The Barn Hotel, West End Road, Ruislip

LPA REFERENCE 7969/APP/2023/1473 & 7969/APP/2023/1833

**RESPONSE TO LB HILLINGDON FEEDBACK ON TFL, URBAN DESIGN AND
CONSERVATION, ACCESS, POLICY & PUBLIC OPEN SPACE**

SHEET		
Building 2 M4(3) 1b2p		
Date 01/10/23	Project number Project Number	Scale (@ A3) 1 : 50
Drawn by	DRG NUMBER	Author 22 0063-51 A

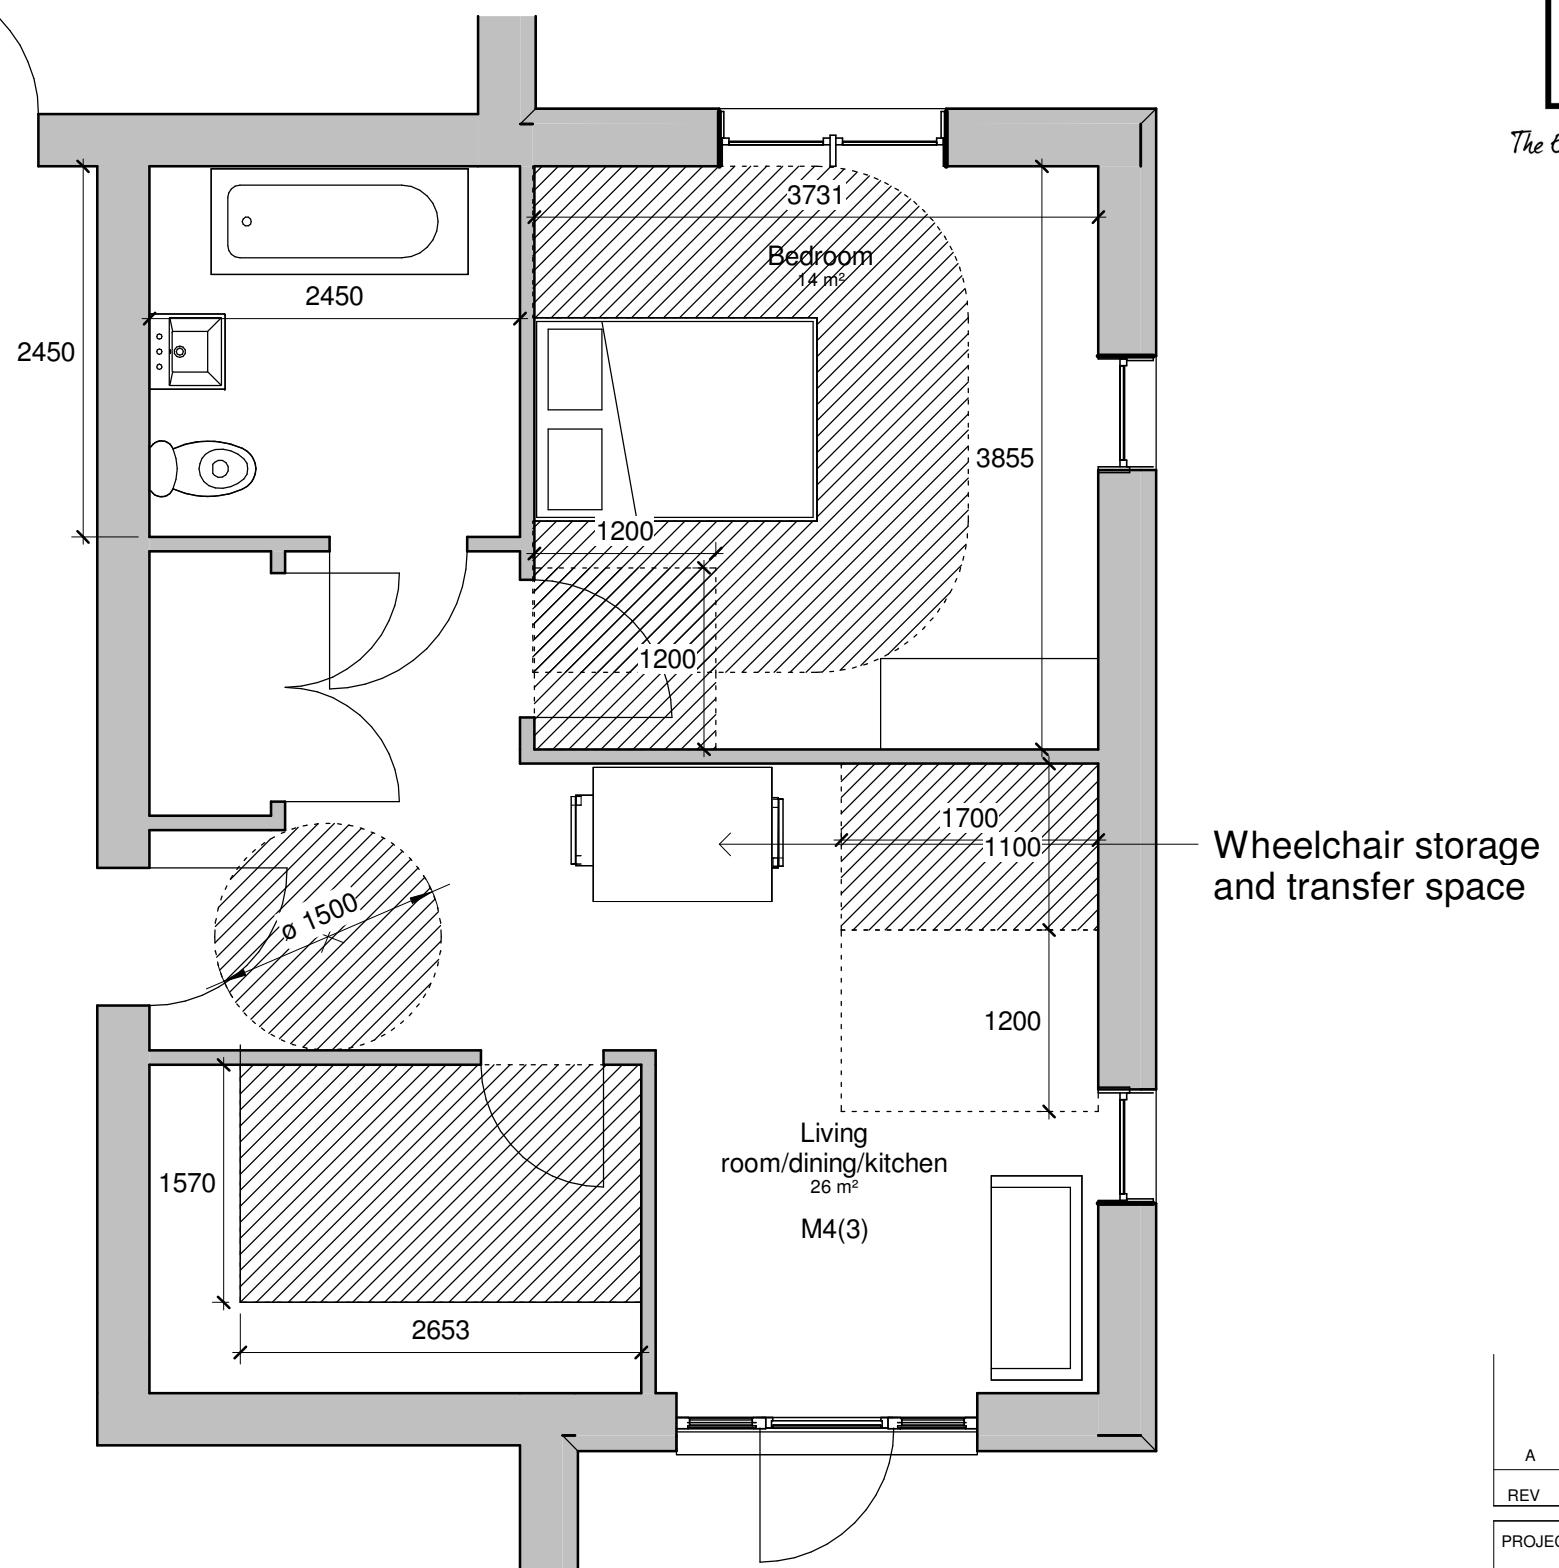
A detailed floor plan at no less than 1:100 should be submitted for each of the different M4(3) units. All details, to include transfer zones, wheelchair storage area, and other spatial requirements within bedrooms, bathrooms, living and dining areas, should be shown on a separate plan for every different unit type.

We had believed these plans to be submitted with the application. Please find attached plan numbers 22 0063 50 A and 22 0063 51 A that shows the M4(3) layouts.
